SGH/LCN/4490

Application for variation of Condition No. 2 (approved drawings) in connection with the proposed alterations and extension to Nabside Farm, Moor Lane, Whalley, Nr Clitheroe, Lancashire, BB7 9JQ for Mr and Mrs Crouch (Planning Approval Ref: 3/2016/0340)

PROPOSED SIDE ELEVATION (WEST FACING) 1:100 Scale

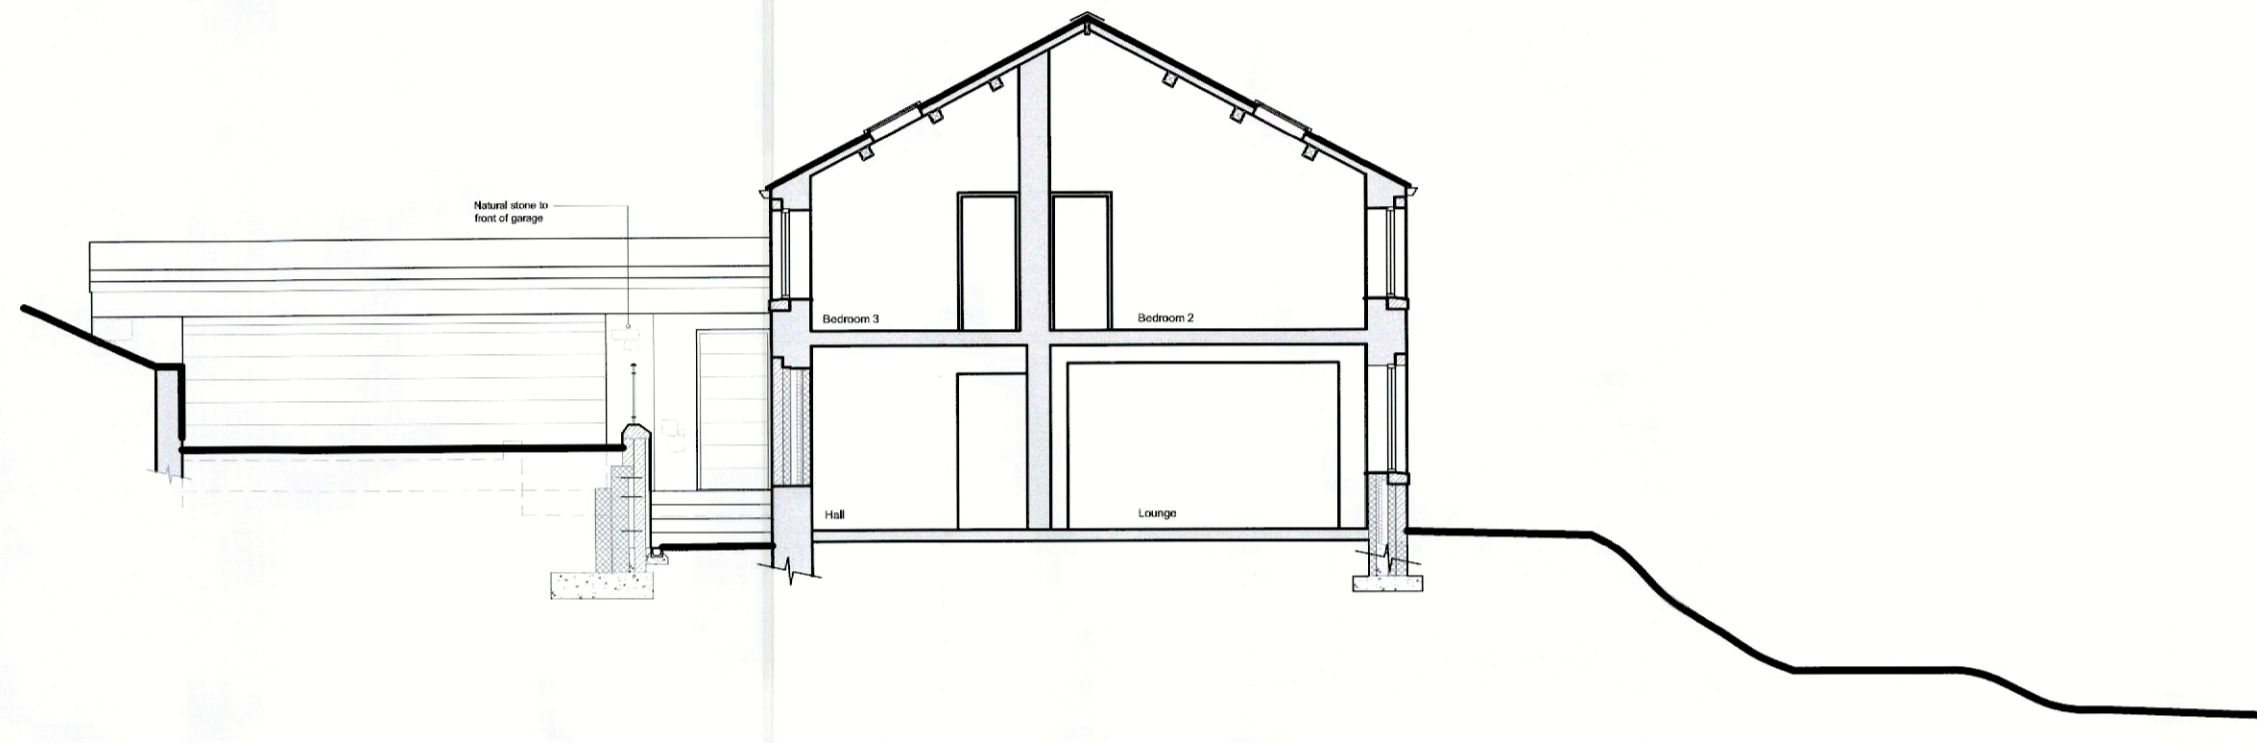
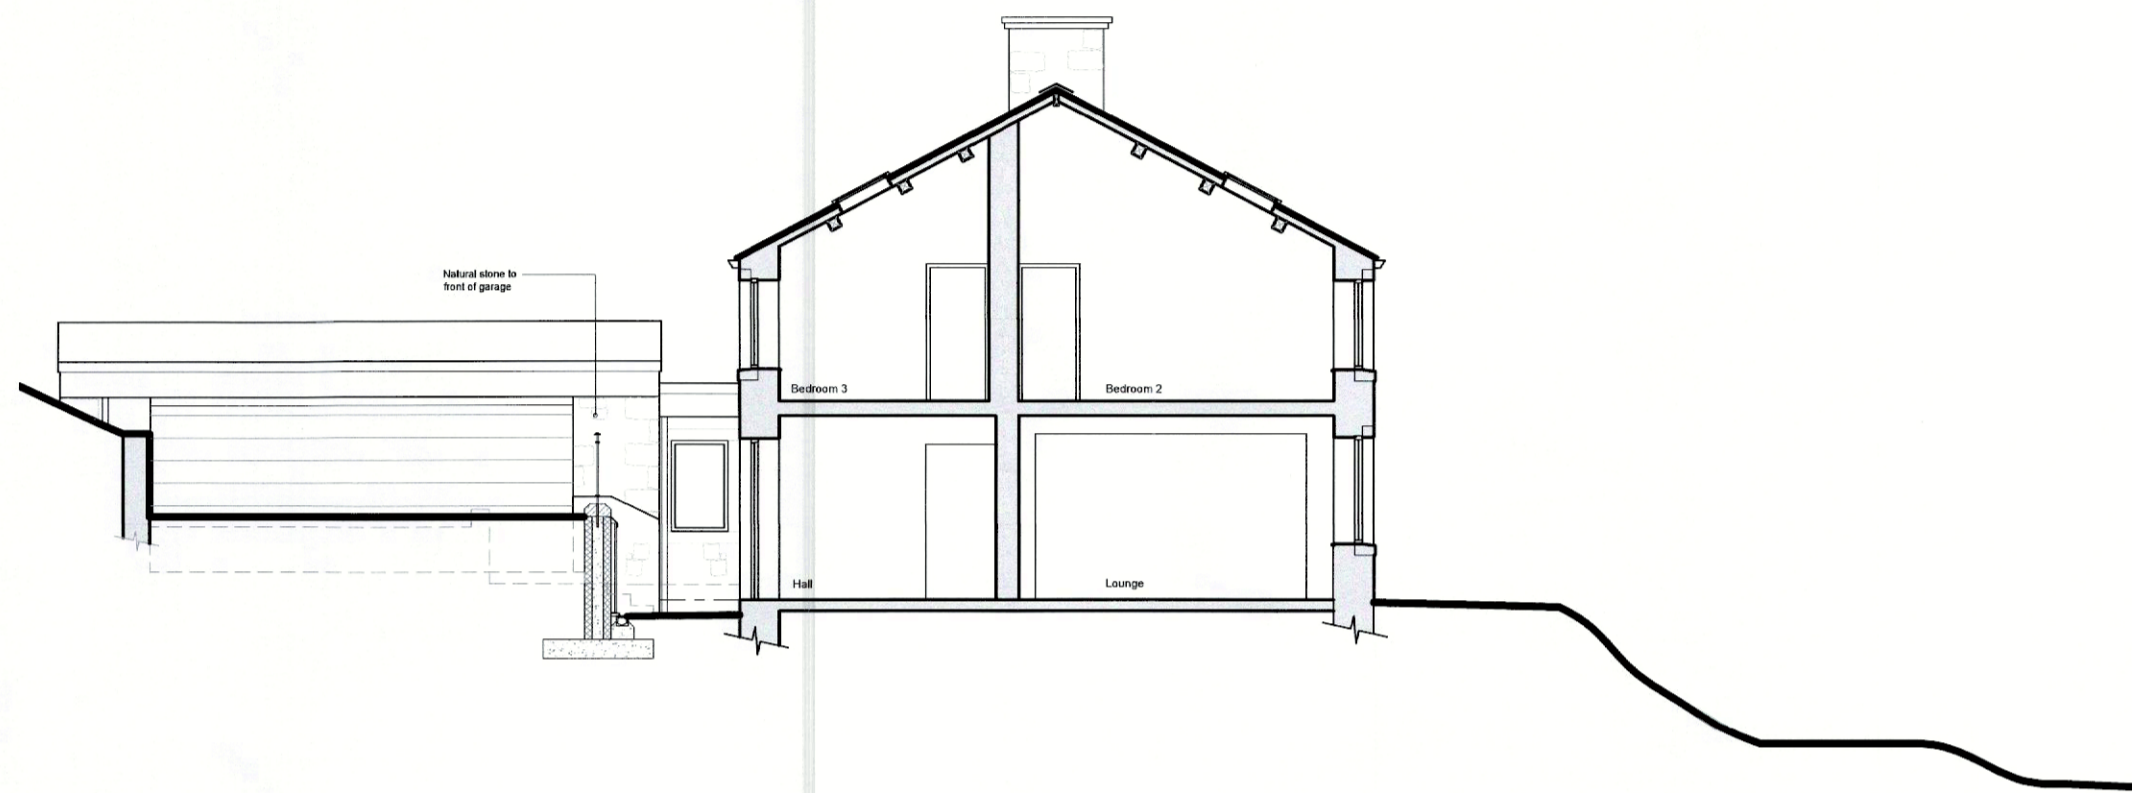
The amended design now incorporates a utility room in part of the new garage (without losing any parking space), and the length of the proposed bedroom extension has been extended by 0.5M towards the north (still set back from the original house wall). There are also some minor fenestration changes sought to the guest bedroom and utility room.
